Recommendation Report for Planning Permission for Works or Extension to a Dwelling

REF NO: FG/71/18/HH

LOCATION: 23 Sea Lane
Ferring
BN12 5DP

PROPOSAL: Two storey extension

Proposed Side Elevation(East), Scale 1:100

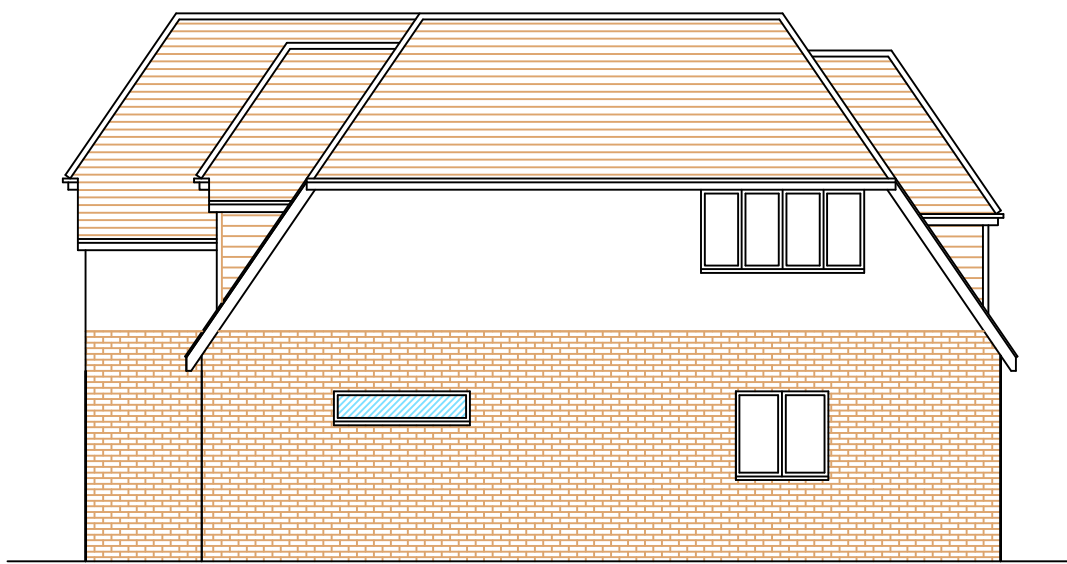
Property number 27 is sited the other side of the access to adjoining property number 25. From an assessment of the plans 2 rooflights are proposed into the eastern roof slope, which would serve ensuite and a bedroom. It is not clear from the plans what the cill height, from the floor of the rooms they would serve, would be. From an assessment, officers note that there are trees and planting to the eastern boundary but that due to the height of the rooflights views could be out over the tree/planting screening. As such it is considered that any views would be out over the access to number 25 toward the rear amenity space of number 27. Officer's note that the distance from the rooflights to the boundary of number 27 would be approximately 16-16.5 metres which is considered a fairly short distance. As such, given the positioning of the rooflights it is considered that some overlooking toward the rear private amenity space of number 27 could occur. It is considered that while the rooflights would be set into the roofslope of the proposal, which would help to limit any overlooking, detrimental overlooking of the primary amenity space to the rear of number 27 could occur. As such, should planning permission be granted a condition requiring these windows to feature restricted opening and be obscure glazed up to a height of 1.7 metres from the floor of the rooms they serve. Officers note that the rooflight serving the bedroom is not the only window serving it and as such there a means of escape could still be provided via the larger window in the rear elevation. As such it is considered that no detrimental overlooking would occur toward property number 27.

- 3 The rooflight, serving the bathroom, in the eastern roofslope shall have obscure glazing and be fixed shut to be permanently non-opening up to 1.7m from the ground floor of that bathroom.

- 4 The rooflight, serving the bedroom, in the eastern roofslope shall have obscure glazing and be fixed shut to be permanently non-opening up to 1.7m from the ground floor of that bedroom.

Proposed Rear Elevation (North), Scale 1:100

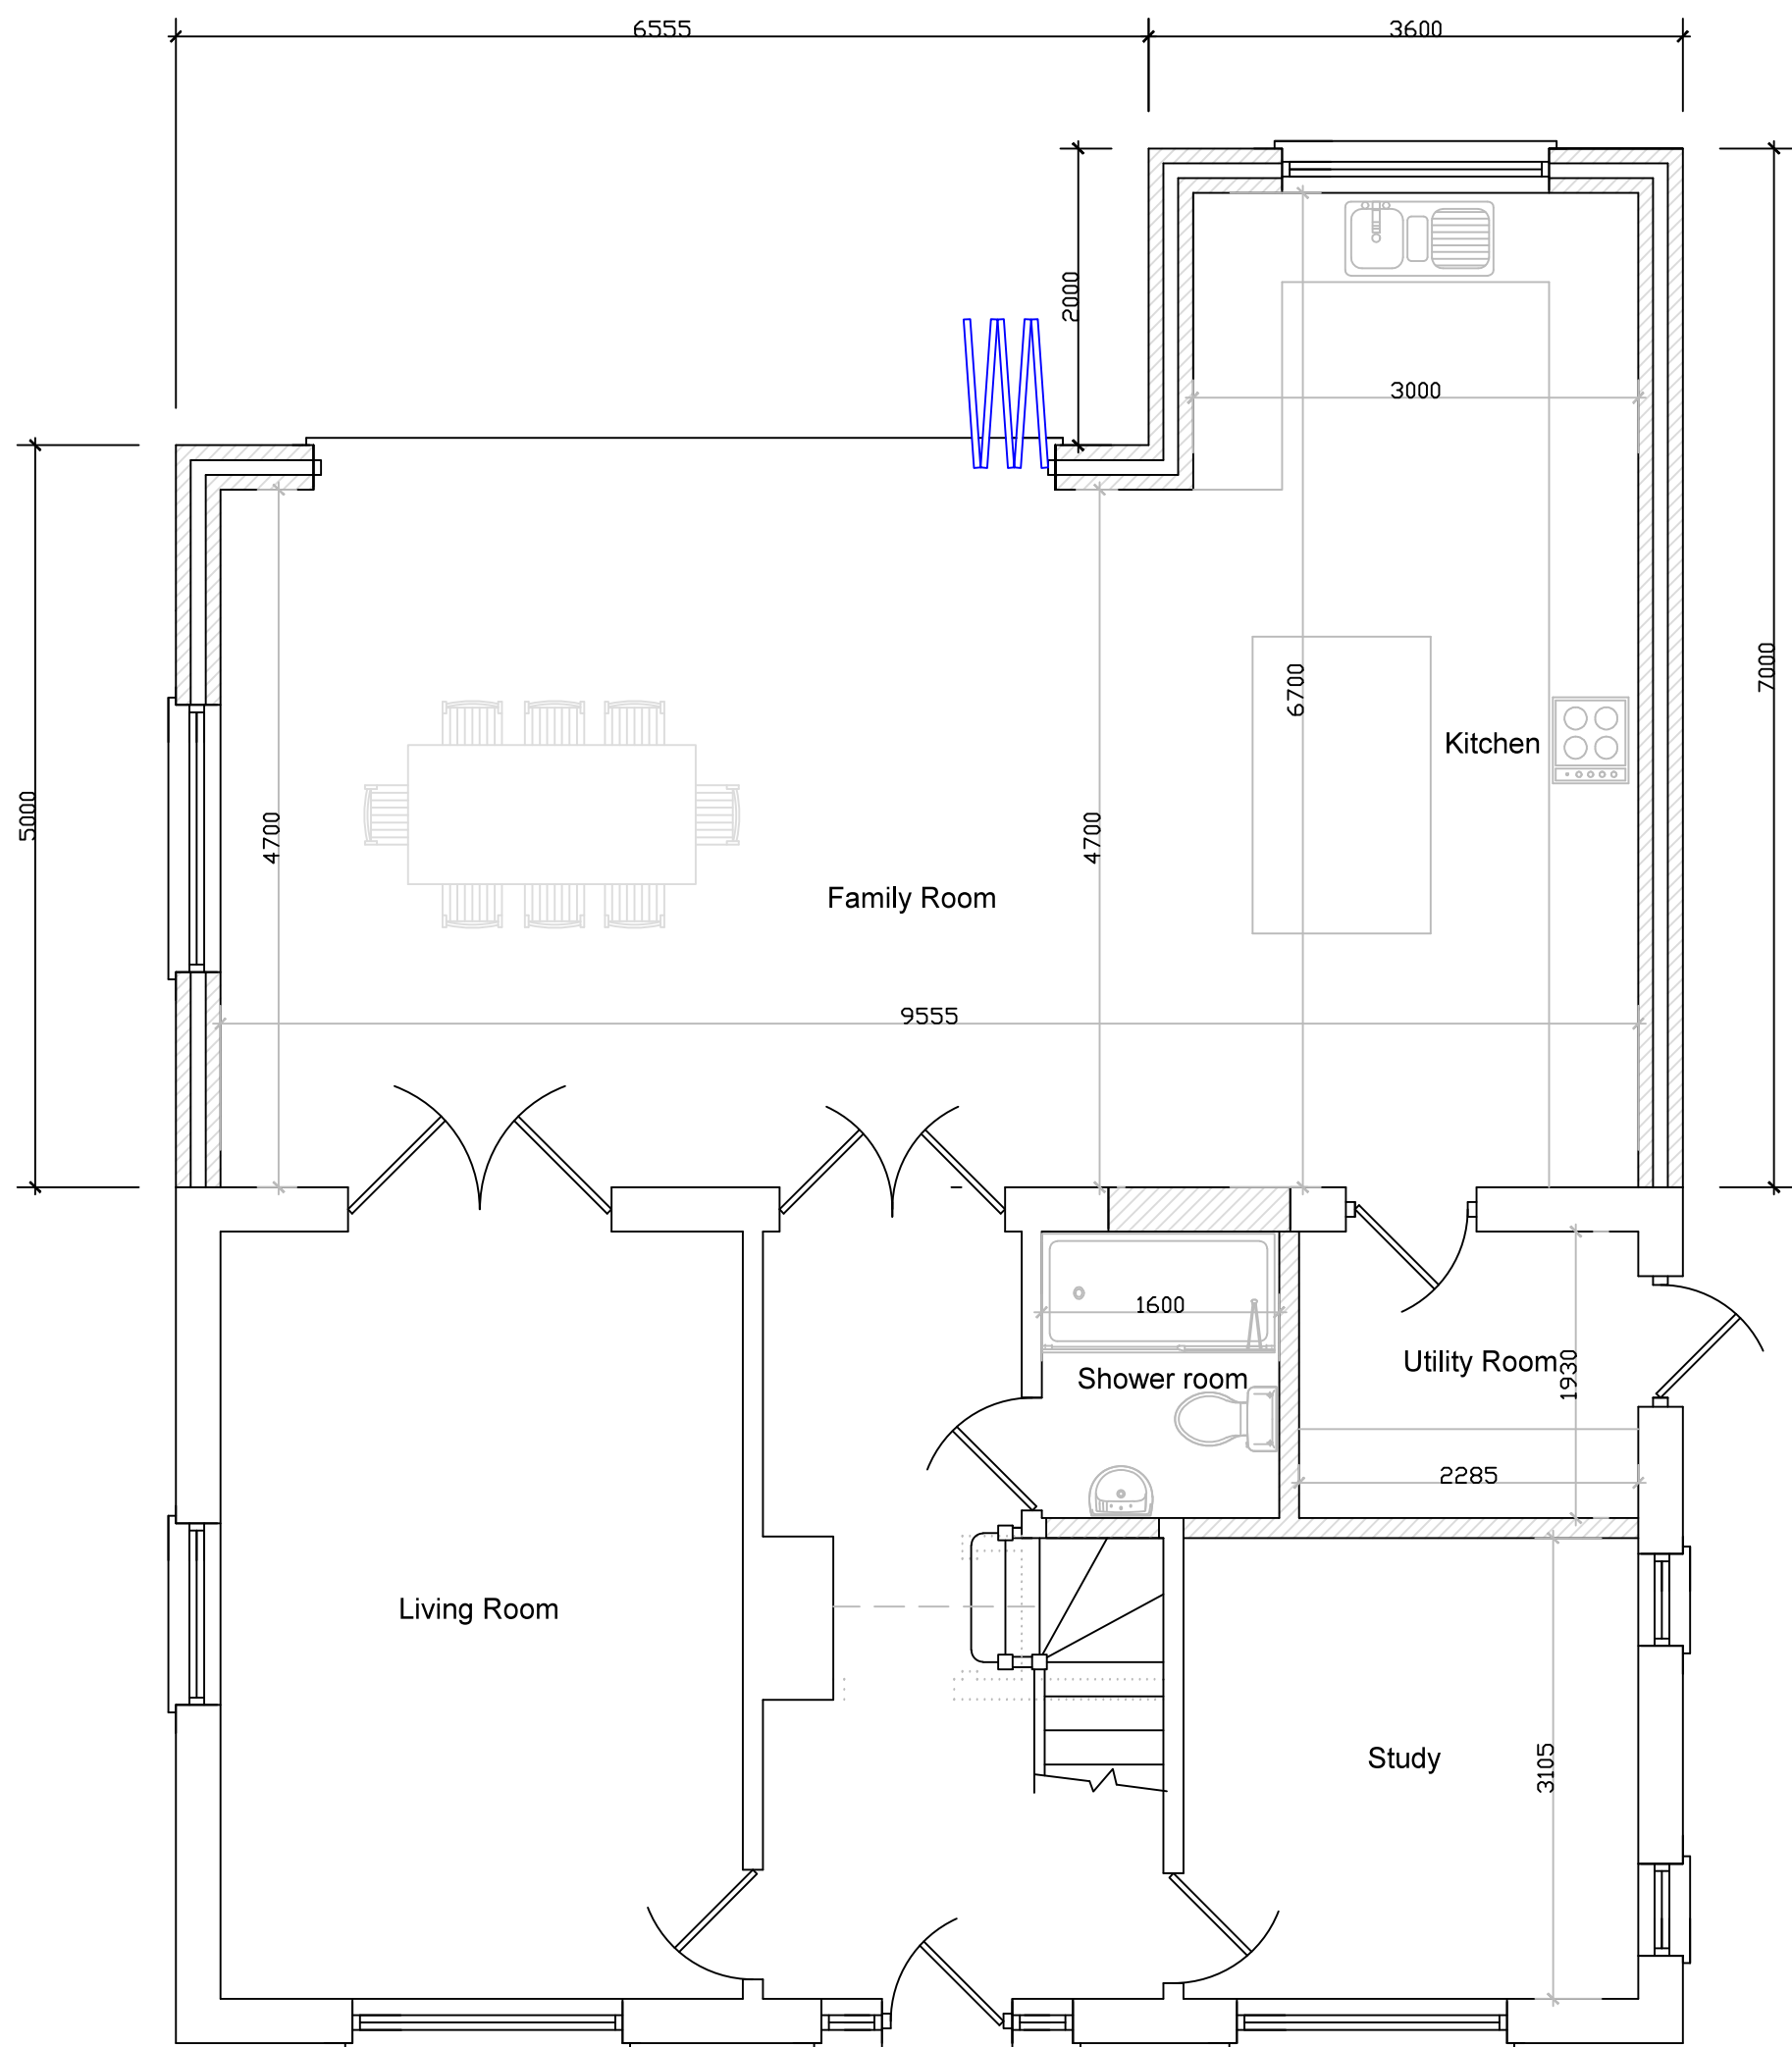
Officers note that the proposals would not be subservient, as the rear extension would have a ridge height the same as that of the existing dwelling.

From an assesment of the plans and the Officer's site visit it is considered that overlooking from the proposed rear dormer window, serving a bedroom, would occur out over the area directly to the rear of adjoining property number 21. This area is considered to be the primary amenity space (first 3m to rear), which is considered not to be ideal. However, Officers note that there are no permitted development (PD) restrictions which would restrict the insertion of a rear dormer into to the rear roof of the existing dwelling. Officers note the condition imposed on previously granted application ref: FG/96/89 - no additional windows into the west elevation, however the proposed dormer window would be into the northern elevation of the proposed rear extension, not the western elevation. From an assesment of the plans and the PD legislation, officers consider that a similar sized dormer could be inserted into the rear roof of the existing dwelling without planning permission and due to its position further back that that proposed, it is considered that the dormer would have a greater impact with regards to overlooking toward number 21. Therefore, on balance, having regard to the PD. fall back position officers consider the level of overlooking from the rear dormer, while not ideal, would be acceptable.
